# Rezoning Transportation Analysis

Petition Number: Insert Zoning Petition #2022-006

## Revision Log:

Date	Description
06-23-22	First Review (PDM)

Rezoning Plan

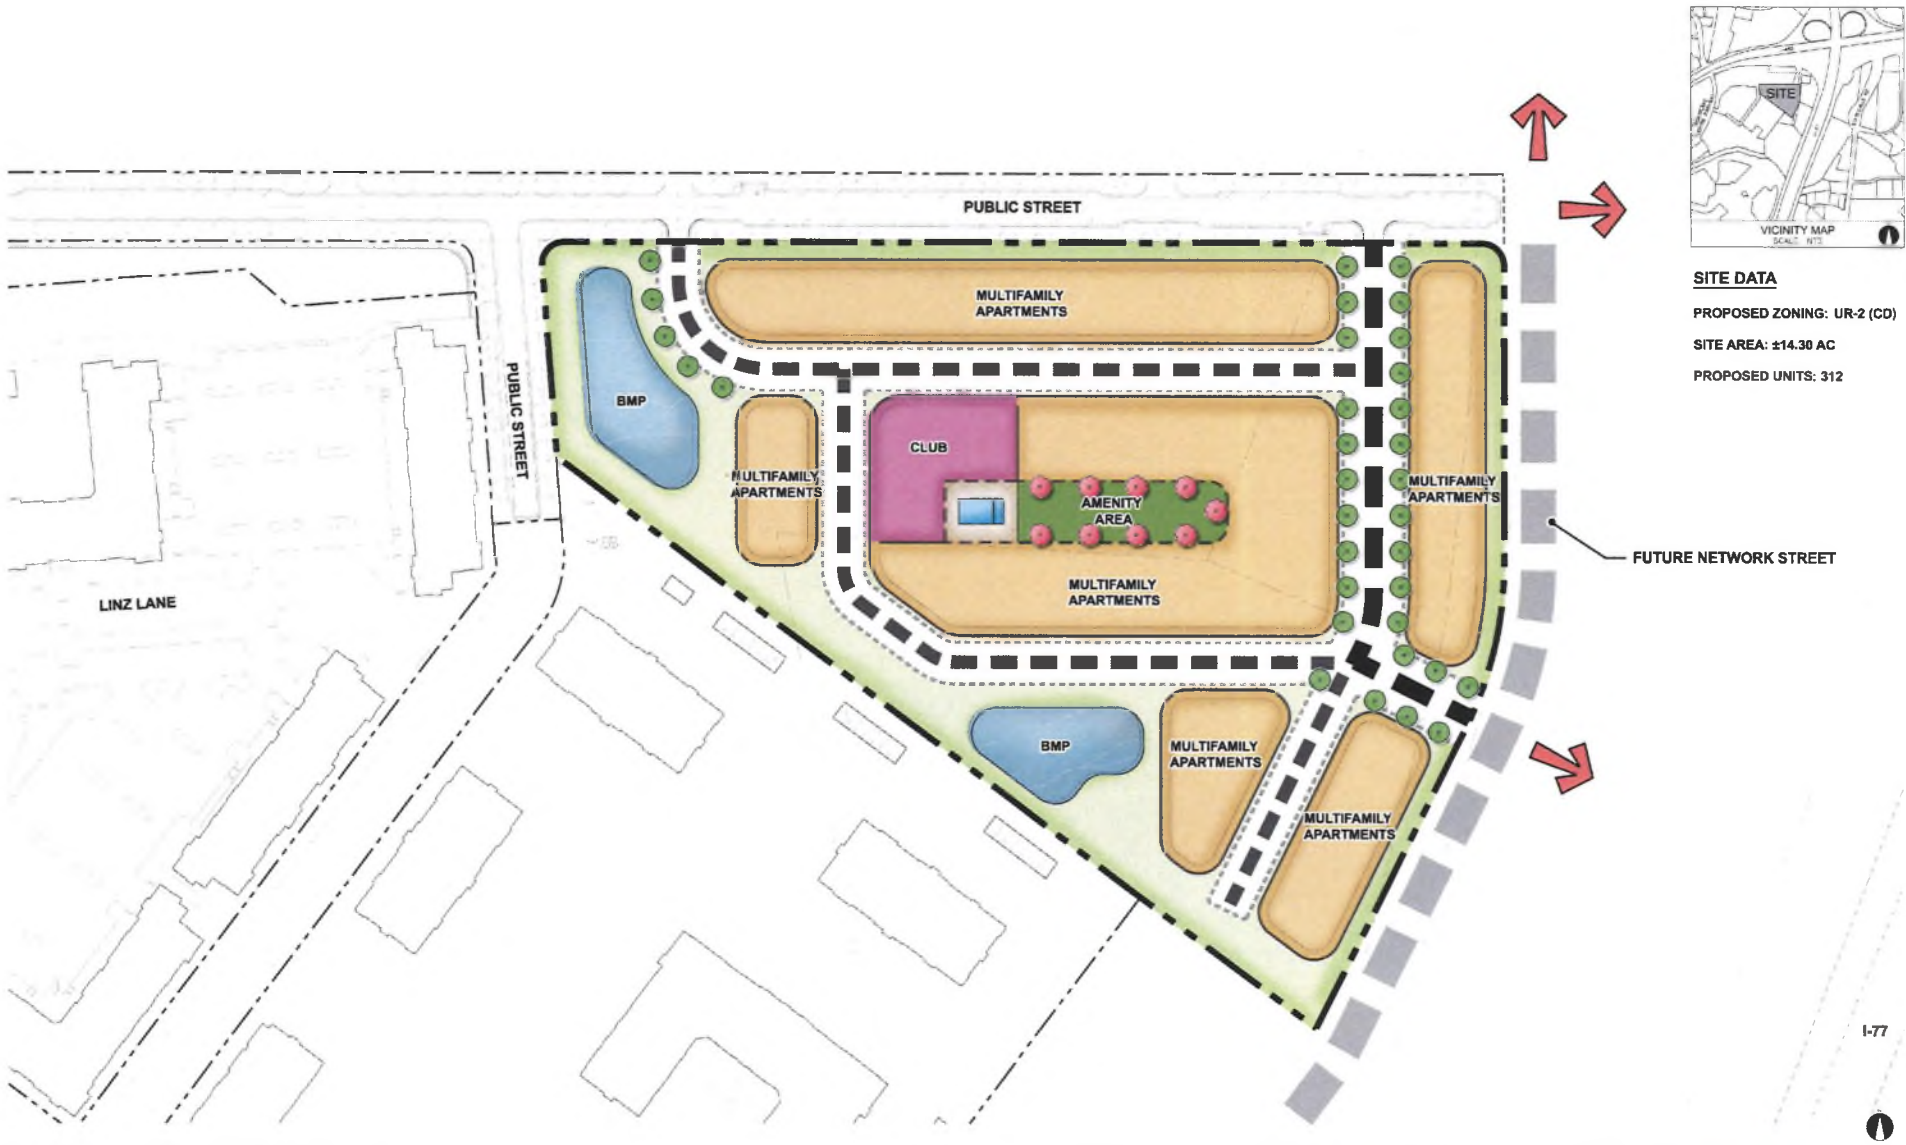
Label and dimension the curb and gutter from the centerline for each road on the site plan.

3. Revise site plan and conditional note(s) to commit to installing both public streets that are identified as "public street by others" on the site plan. A new access location on Northlake Centre Parkway will be required by CDOT for this petition. Coordinate roadway responsibilities with RZP 2022-010 as necessary.
4. Revise site plan and conditional note(s) to commit to dedicate 38.5 right-of-way from the road centerline of each public street. The site plan shall label and dimension the right-of-way from the road centerline.

- Revise site plan to stub the proposed street within the existing ROW for future development.

- Revise site plan and conditional notes to reconcile the existing versus proposed ROW along the east side of the property. The future street alignment should fall within existing ROW. Verify ROW width and provide any additional ROW required for a commercial wide roadway section per CLDSM U-05A.

7. Revise site plan and conditional note(s) to commit to construct an 8-foot planting strip, and 8-foot sidewalk on the proposed public streets per Chapter 19. The site plan shall label and dimension both items from the back of curb and gutter and road centerline.
8. A site plan note(s) specifying dedication and fee simple conveyance of all rights-of-way to the City before the site's first building certificate of occupancy is issued as needed. CDOT requests rights-of-way set at 2' behind back of sidewalk where feasible.
